TECHNICAL MEMORANDUM

Project No. 07-1121-0037

**GEOTECHNICAL CONSIDERATIONS – REVISED
BLOCK 14 – 25 OVERBERG WAY
BRIDLEWOOD TRAILS SUBDIVISION – PHASE 2
OTTAWA, ONTARIO**

GRADING PLAN – 114013-GR

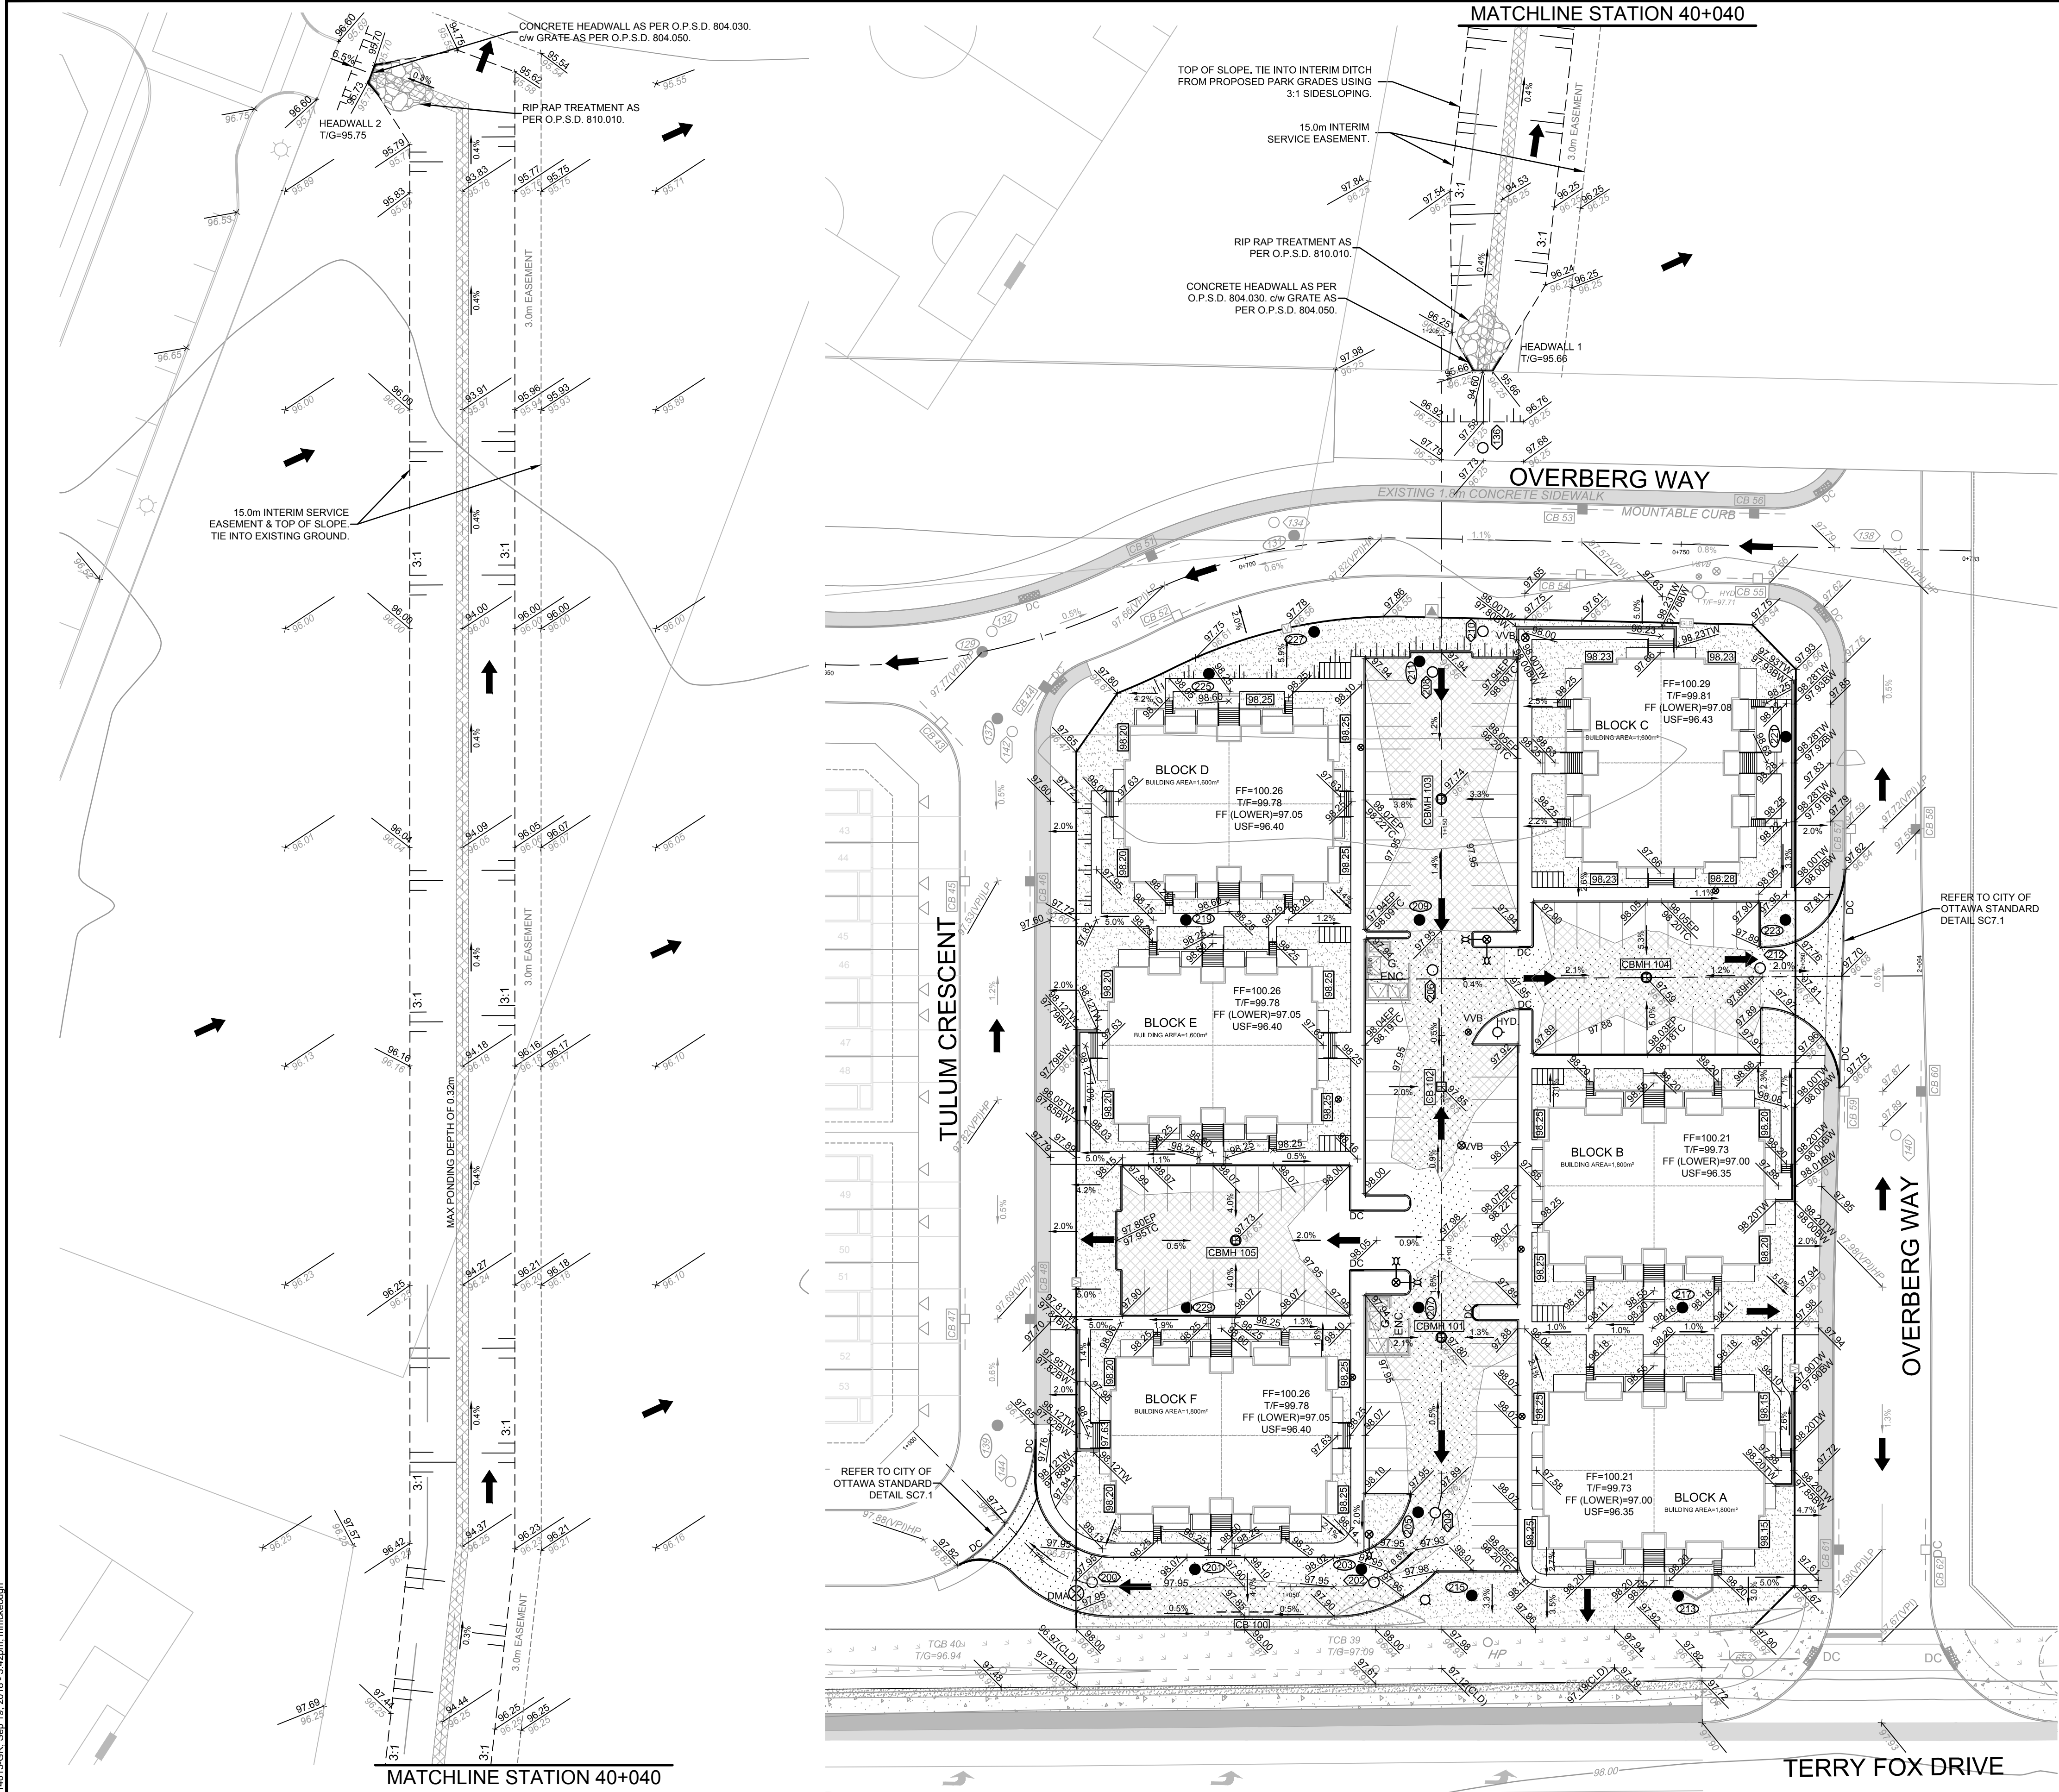
For Blocks A to F, the grading plan (Drawing No. 114013-GR, Revision 9 (dated September 7, 2018) prepared by Novatech Engineering Consultants Ltd. – Project No. 114013) indicate the following:

Based on the above grading plan and a review of the specific geotechnical data for this part of the site, expanded polystyrene (EPS) Geofoam light weight fill *is* required in the **porch and above any exterior footing projections at the limits shown on GEO-01 (i.e., EPS should extend out from the foundation walls towards the edge of the footings)**; the EPS must extend a minimum of 1.0 metres out from the foundation walls, even if the footings do not. The EPS should extend from the top of the footings to at least the underside of the topsoil at the finished grade level, with a maximum topsoil thickness of 0.3 metres. A sketch showing the typical EPS placement is attached.

The finished grades, lightweight fill requirements, and underside of footing elevations were reviewed and are found to be in accordance with the guidelines and recommendations provided in the geotechnical report prepared for this site and, as such, are considered acceptable from a geotechnical point of view.

For the pavement areas in Block 14, there are areas of the parking lots and roadways that exceed the 1.2 metre grade raise as discussed in the geotechnical report. Where the grade raise exceeds 1.2 metres, the EPS Geofoam light weight fill will be required for the full plan area of the roadways and parking lots with a thickness such that the grade raise fill is limited to a thickness of 1.2 metres (i.e., about 0.3 to 0.5 metres thick).

The finished grades of the parking areas with the lightweight fill requirements, discussed above, were reviewed and are found to be in accordance with the guidelines and recommendations provided in the geotechnical report prepared for this site and, as such, are considered acceptable from a geotechnical point of view.
